PLAN EXAMINATION RFI HOLD

PROJECT/SITE DESCRIPTION:	DETAILS:
Midtown Building 2 – 8 Story Parking structure with Mixed use space	Review Type: All Trades
PROJECT ADDRESS:	Plans Date: 4/5/2016
59 Somerset St – Portland, Maine	# of Sheets: 80
	Project Area (sq. ft.): 299,737

Building Plan Reviewer: Adam Roder, P.E. Status: Hold Pending Additional Information

E-1.1

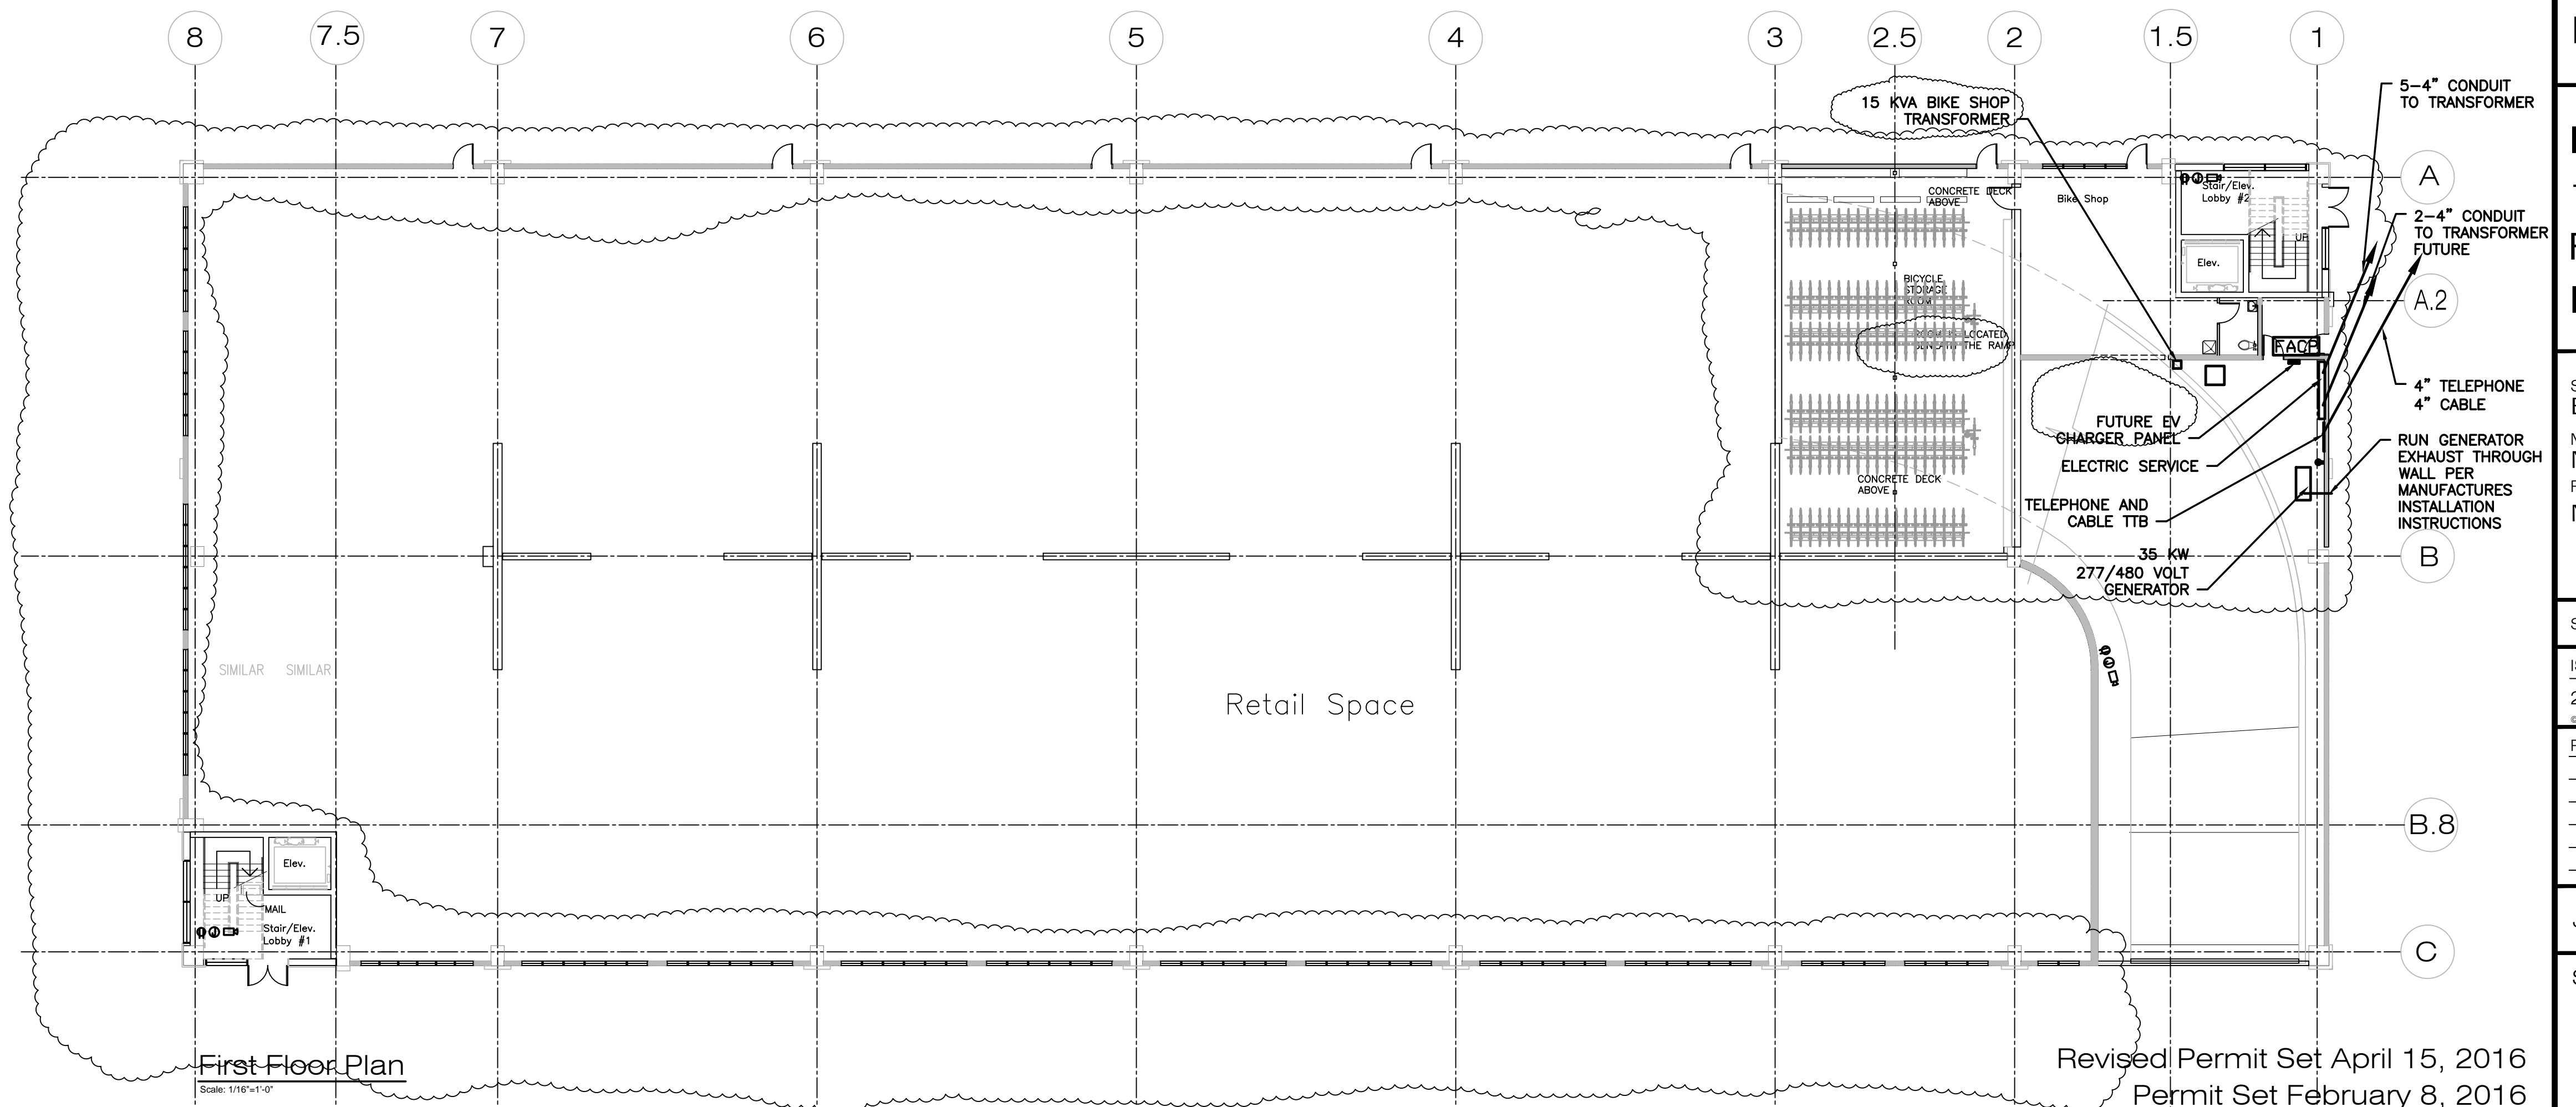
- Electrical drawings do not indicate GFIC outlets anywhere. Per 2014 NEC GFIC outlets should be installed through the project.
- The pad-mounted Transformer is not located on the drawing. Additionally, there is no Site Utility Plan indicating its location on the project. Please provide additional clarification and/or revise drawings as required.

BUILDING 2 ROOF DRAIN RISER
N.T.S.

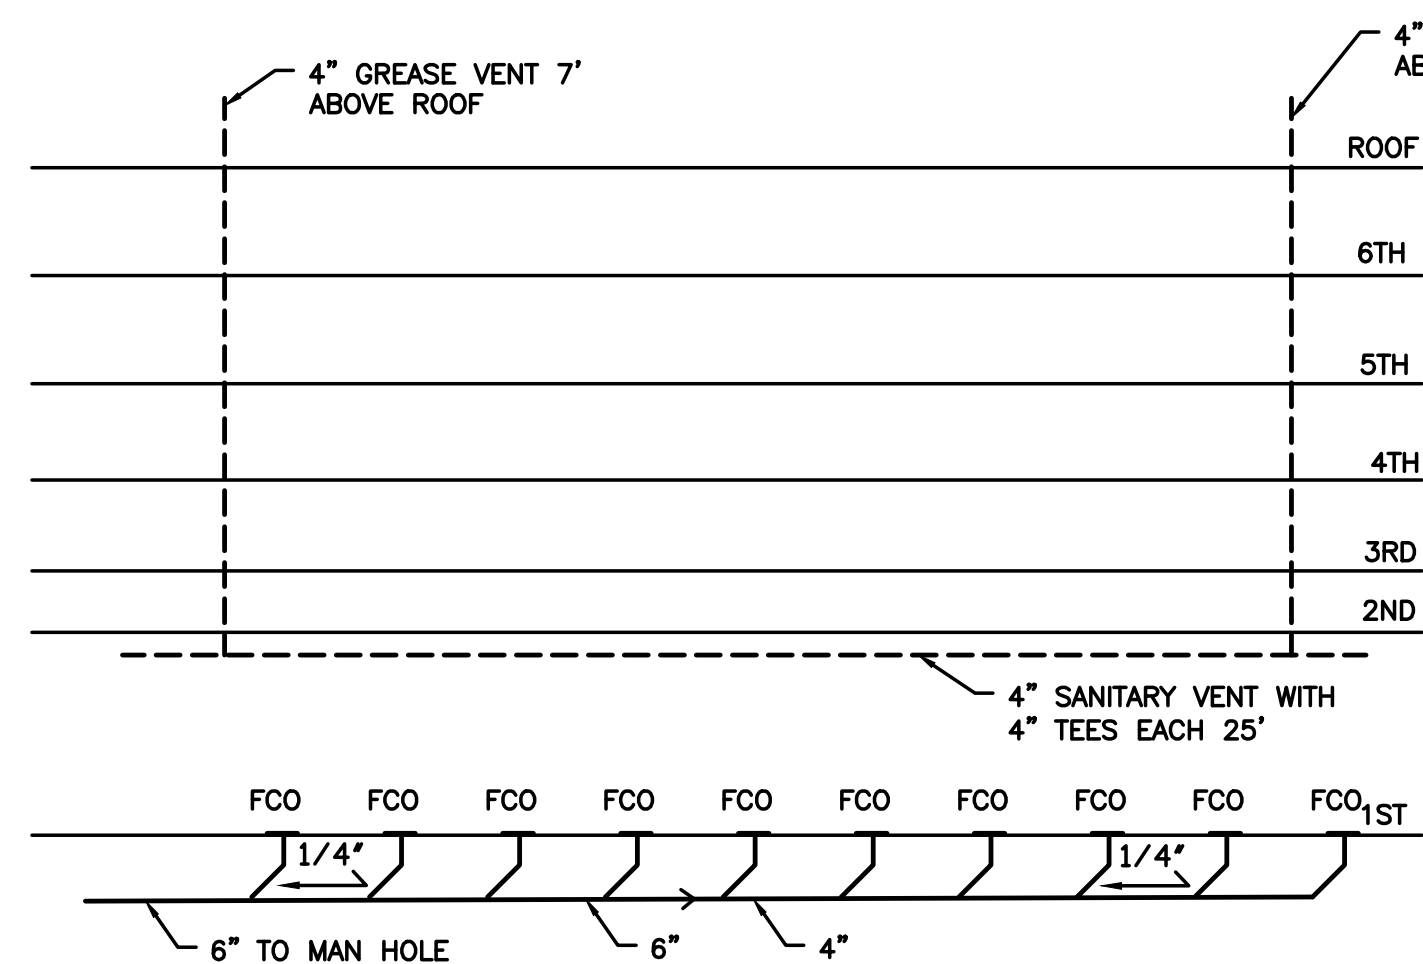
- While it appears that the Roof Drain Riser indicates the areas of drainage and the pipe sizing is correct, there is no Site Utility Plan that indicates where these storm drainage lines tie-in. As the sanitary, currently are shown as dead-ending to nowhere. Please provide additional clarification and/or revise drawings as required.

BUILDING 2 1ST LEVEL SANITARY WASTE RISER
N.T.S.

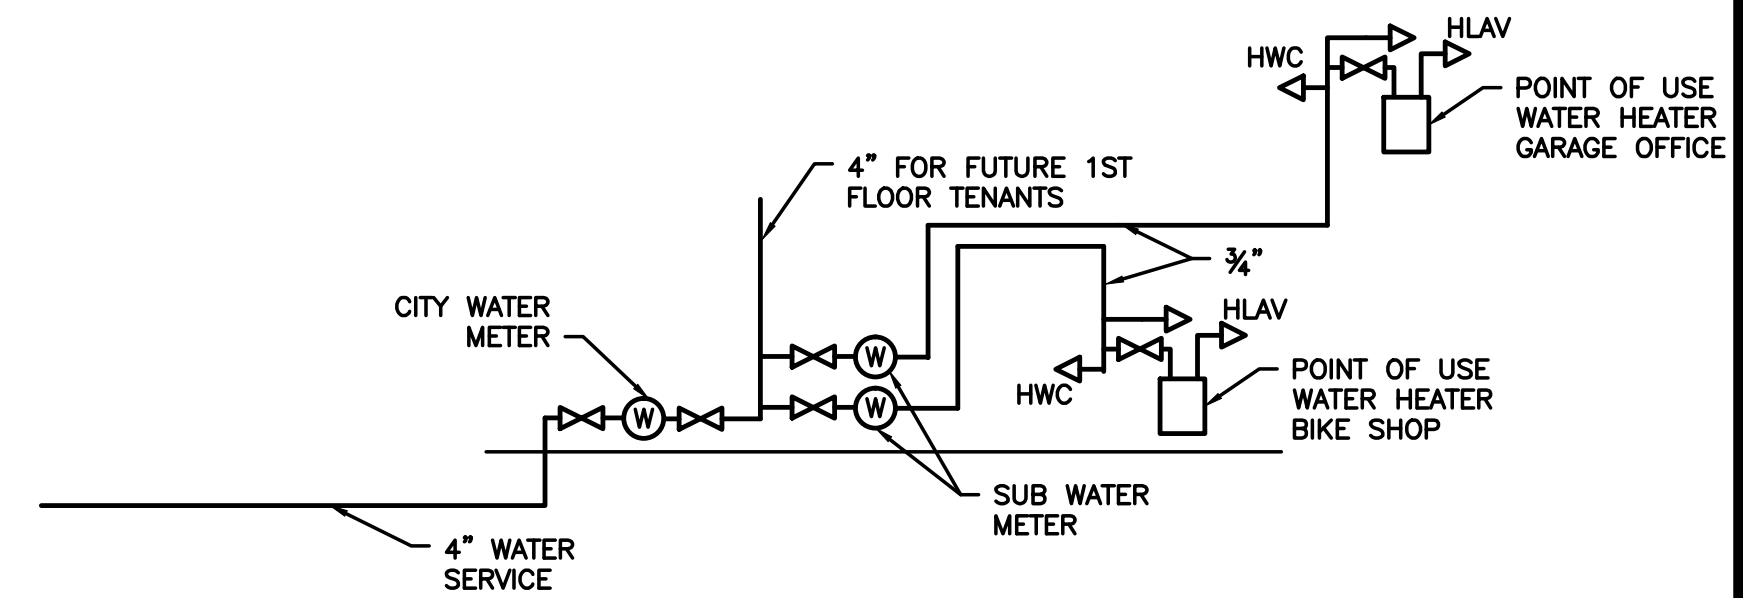
- On the “RETAIL/RESTAURANT SANITARY AND GREASE PIPING plan “GW” is labeled on the Toilet Room sanitary sewer as it angles towers the 1000 gallon Grease Trap. Please advise if this is a drafting error as currently it is shown that the toilet waste was piped into the Grease Trap. As this would not only be against the Plumbing Code, but constitute a significant mess if constructed. Please provide additional clarification and/or revise drawings as required.

- There are no piping details for piping into and around the grease trap. Please provide additional clarification and/or revise drawings as required.
- There are no Grease Trap or Oil Separator details. Please provide additional clarification and/or revise drawings as required.

- There are 4”, ½” and FCO notes on the drawings that refer to nothing. There are no FCO details or maximum distance between FCO’s called out. There are no Floor Cleanouts indicated for the Sanitary Sewer from the restroom. Please provide additional clarification and/or revise drawings as required.

BUILDING 2 WATER PIPING
N.T.S.

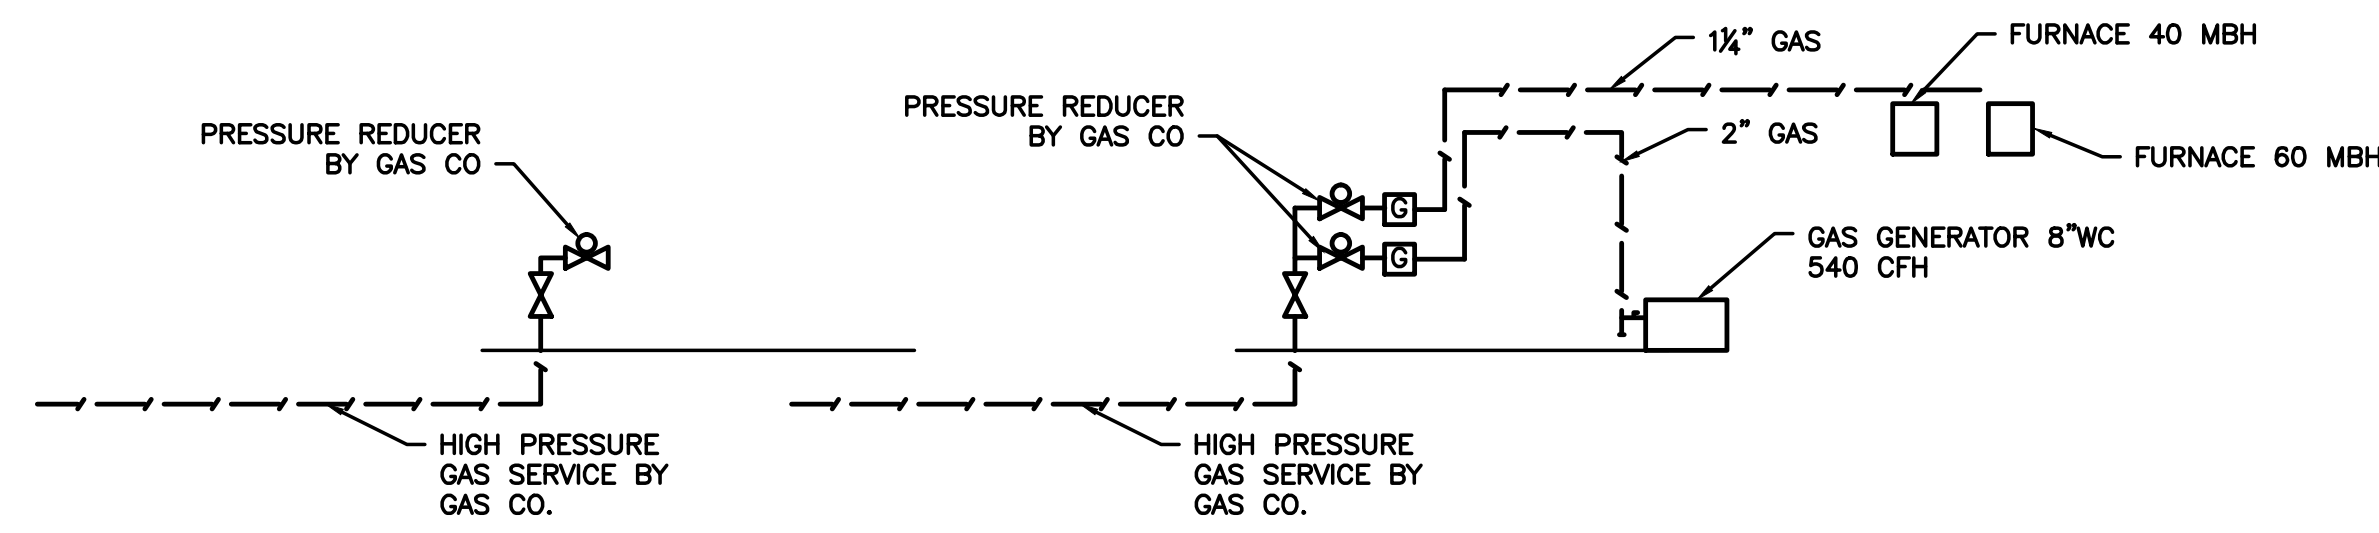
- There is no backflow preventer indicated on the water supply line as required by the International Plumbing Code and no backflow preventer details / specifications. Please provide additional clarification and/or revise drawings as required.
